**SUFFOLK ENERGY ACTION SOLUTIONS'**  
**REBUTTAL OF NGET RESPONSE TO SEAS' RELEVANT REPRESENTATION**  
**WATER AND FLOOD**

**SEA LINK: EN020026**  
**DEADLINE: 2 – December 9, 2025**

**[REP1A-043] - 9.34.1 Applicant's Comments on Relevant Representations Identified by the ExA - Specifically Table 2.54 SEAS- Water and Flood Risk**

Plate 6.10 Spaced puddle clay stanks along the cable route in the areas prone to groundwater risk

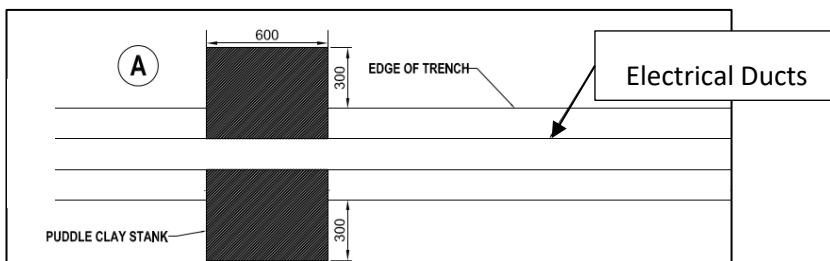
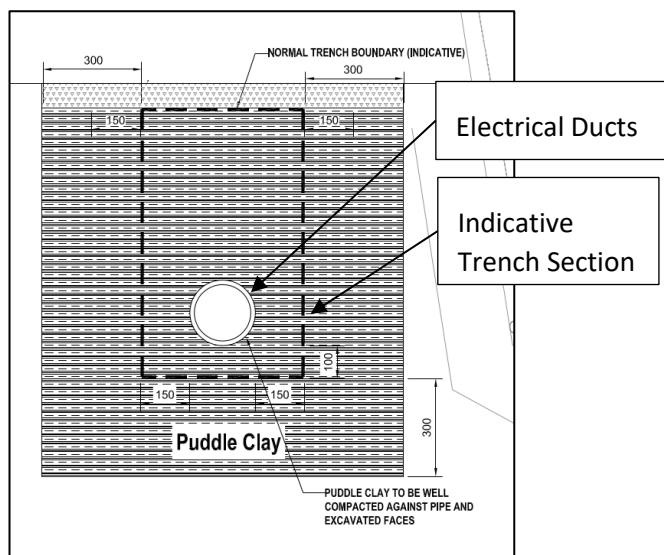
- 28.1. NGET provides **no modelling or analysis** to support the claim that infiltration will not elevate groundwater levels or **affect nearby receptors**, including:

28.1.1. **Residential properties** in low-lying areas (e.g. Friston).

- 28.2. The FRA (APP-292) contains **no plan, section or cross-section drawings** showing groundwater flow paths or potential groundwater mounding beneath infiltration basins.

- 28.4. In the Crag aquifer and shallow groundwater zones around Friston and the Fromus valley, even modest groundwater mounding can materially increase flood risk to properties, utilities and watercourses. Without modelling this pathway, the Applicant has not demonstrated compliance with EN-1’s lifetime flood-risk management requirement.
